## City of Albuquerque Stormwater Construction Site Inspection Report

General Information					
ESC File No.	D17E095A	Project Name:	Guthrie's Garage		
NPDES Id. No.	NMR1005KO	Location:	3831 Masthead Street		
7/12/2023	Owner		Contractor NMR1005M8		
Operator	Headstart Enterprises LP		Wilger Enterprises		
Contact name & title	Jim Guthrie		John Wilger		
e-mail	<a href="mailto:jim@carcrafters.com">jim@carcrafters.com</a>		<a href="mailto:jwilger@wilger.com">jwilger@wilger.com</a>		
Contact Phone #	881-8889		505-345-2854		
COA Inspector	Doug Hughes		Start/End Time:	11:45AM	
Construction Phase:	Cleared				
Type of Inspection:	<span style="background-color: yellow;">Regular</span>	Storm Event	Post Storm Event >0.25"	311/Complaint	Follow Up
Weather at time of inspection?	Cloudy		Temperature: ~	98	
Estimated date of last storm 0.25" or greater	3/17/2023

ENGINEER'S SEAL RONALD R. BOHANNAN NEW MEXICO PROFESSIONAL ENGINEER 7868 4-17-23 RONALD R. BOHANNAN P.E. #7868	3831 MASTHEAD ST ALBUQUERQUE, NM	DRAWN BY pm
EROSION CONTROL PLAN		DATE 4-17-23
		DRAWING
		SHEET # SW-1
		JOB # 2022002

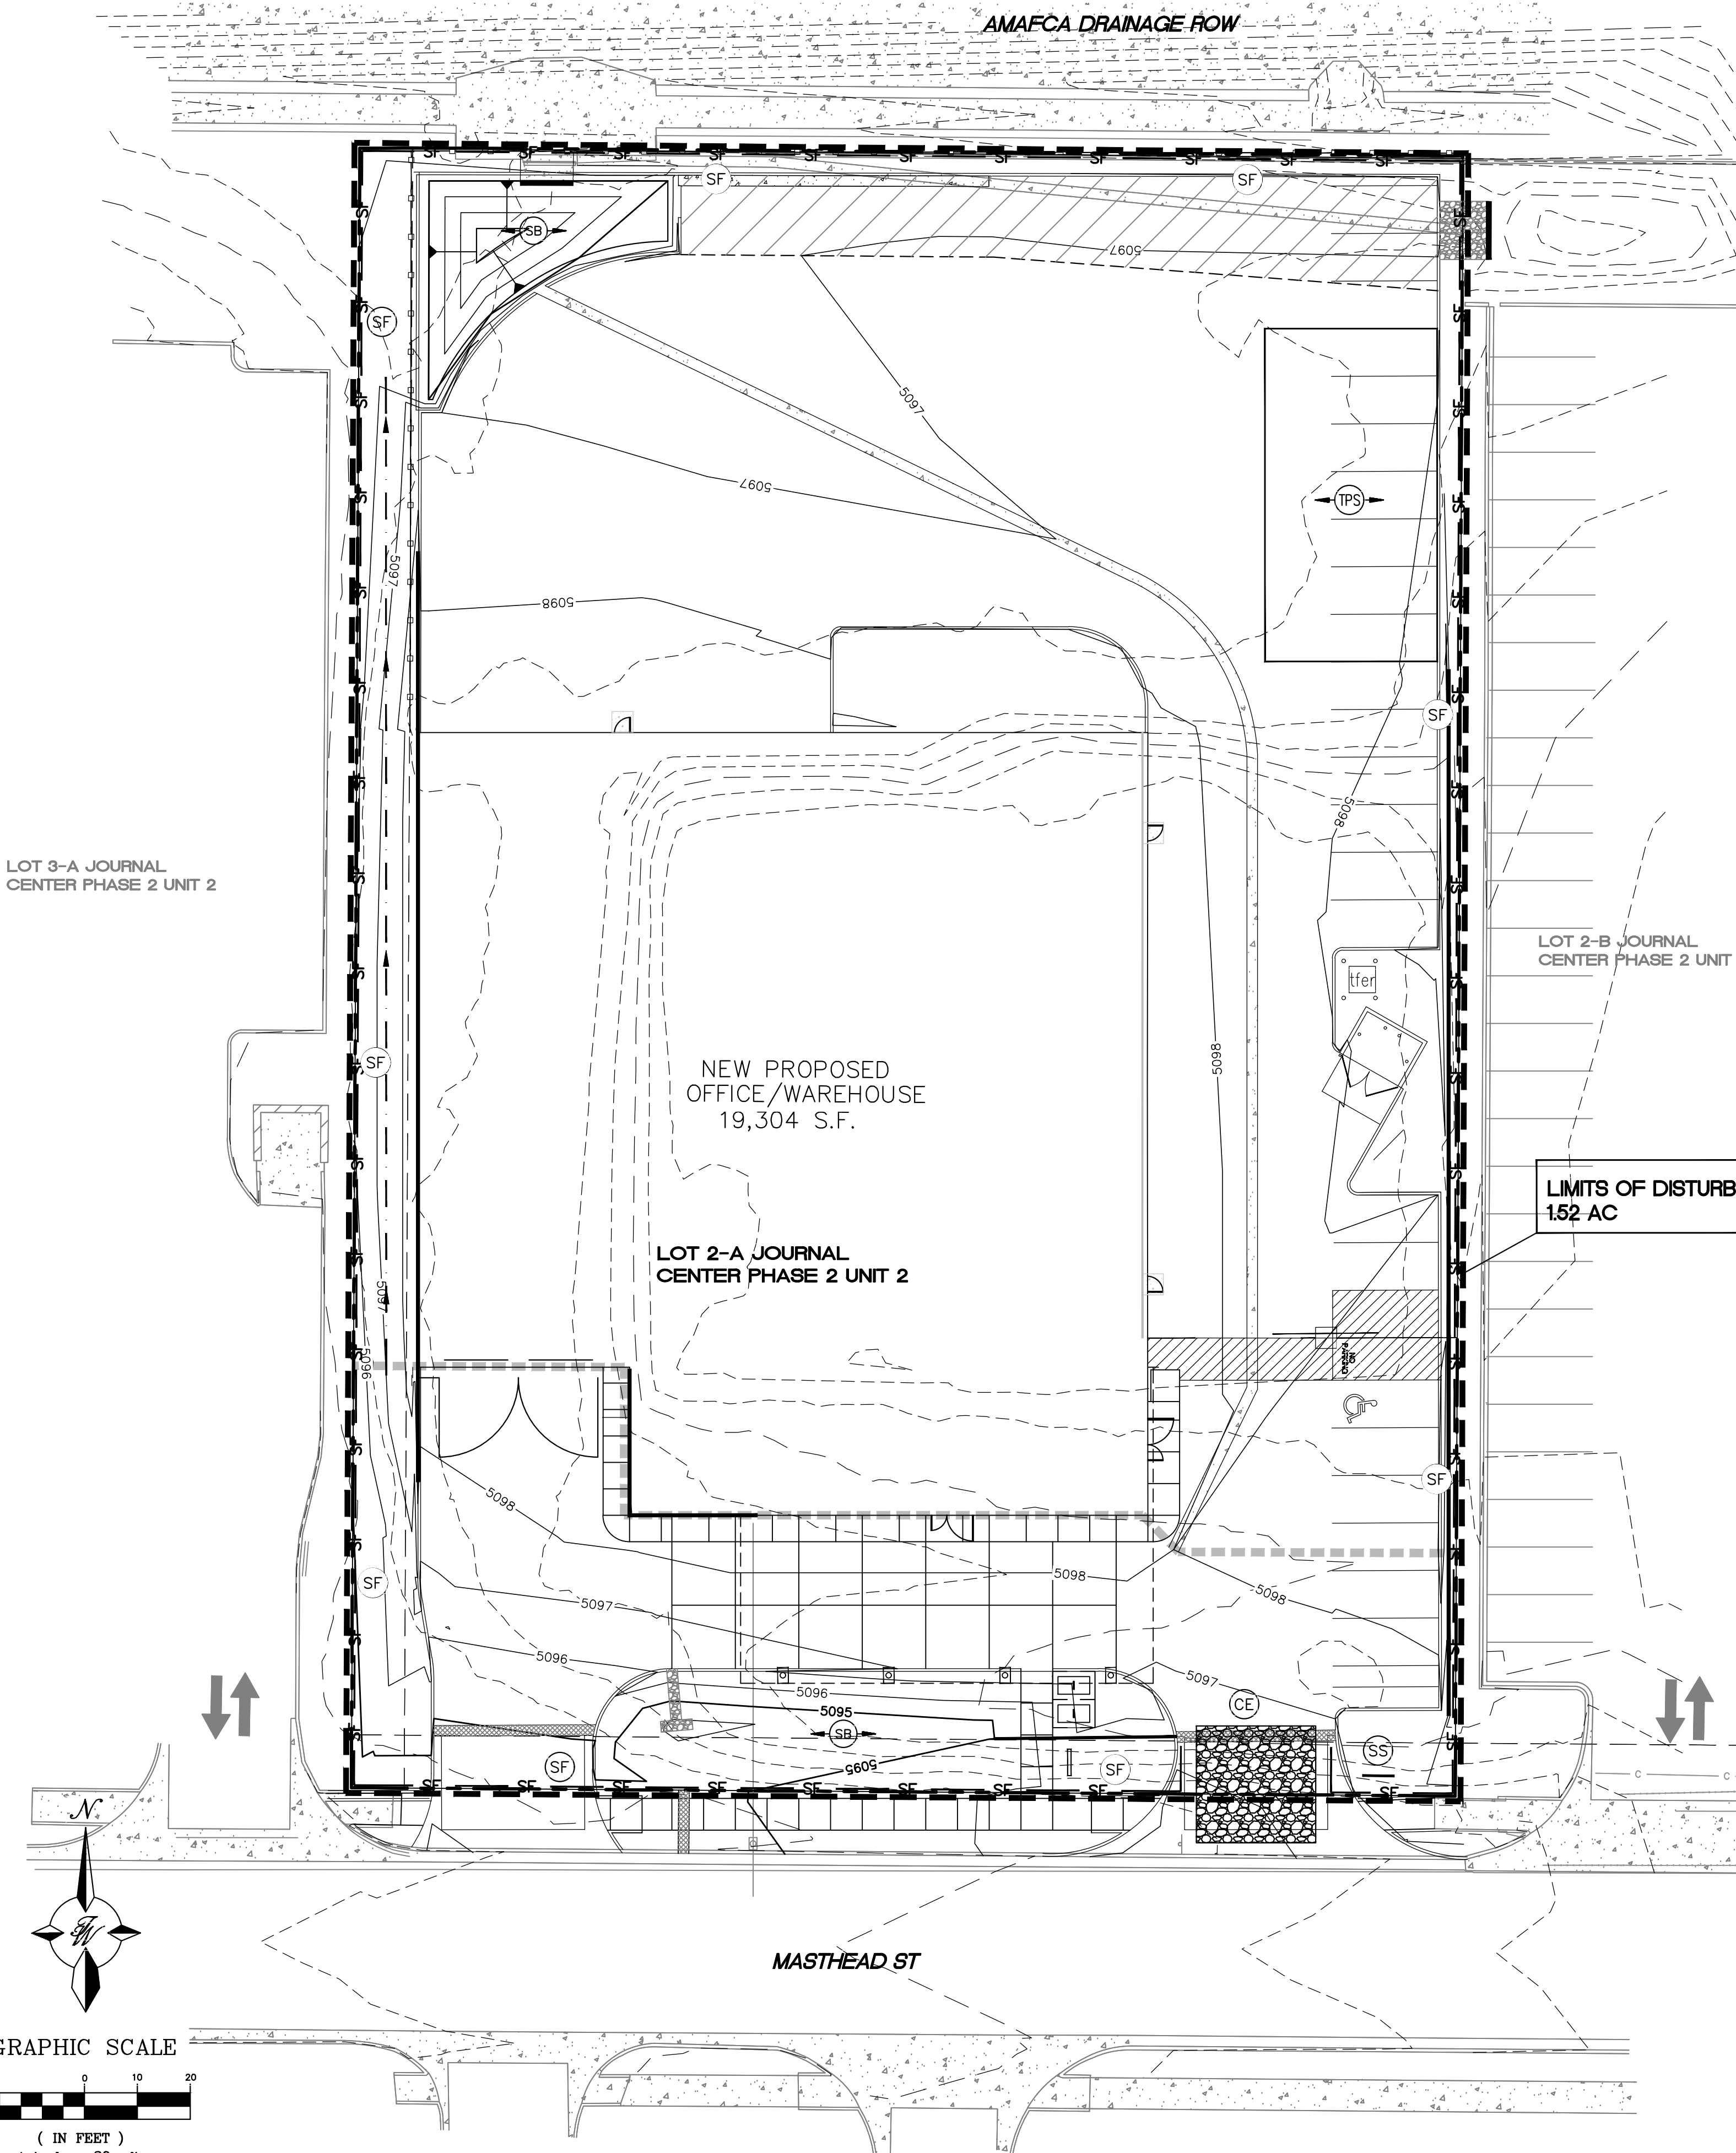
Item Number	Deficiency/ Corrective Action				
1	Your SWPPP wasn't up-to-date and Self inspection reports were not available on-site during the inspection in violation of City Ordinance § 14-5-2-11(C)(1) and in violation of CGP 7.3. The Stormwater team members were not identified, in violation of CGP Part 6 and Part 7.2.2. The operators Certification Statements were not signed in violation of CGP 7.2.10. Training Certificates may be incomplete per CGP part 6 and 7.2.8. Required Mitigation: The SWPPP and inspection reports must be kept up-to-date per CGP 7.1 and available on-site per CGP 7.3. and City Ordinance § 14-5-2-11(C)(1). Corrective action reports are required to reset controls that were incorrectly installed and must be rest (below) per CGP Part 5.				
2	BMPs were installed incorrectly and were not properly maintained. The Construction Entrance (CE) is installed in the wrong place. The CE is in the low corner of the lot creating hole in the Silt Fence and allowing stormwater runoff to escape the site without ponding at the planned silt fence per approved SWPPP Map. The Silt fence is also down and full of sediment in several locations on the west side of the site. The swale on the west side drains to the street, it must drain to the pond on the north. Mitigation: Install controls and establish drainage patterns in accordance with the approved plan making them operational, or completing the repair, by no later than seven (7) calendar days from the time of discovery per CGP 5.2.1. 3. Ensure that all stormwater controls (BMPs) are maintained and remain in effective operating condition during permit coverage per CGP 2.1.4. If at any time you find that a stormwater control needs routine Maintenance, you must immediately initiate the needed maintenance work and complete such work by the close of the next business day.
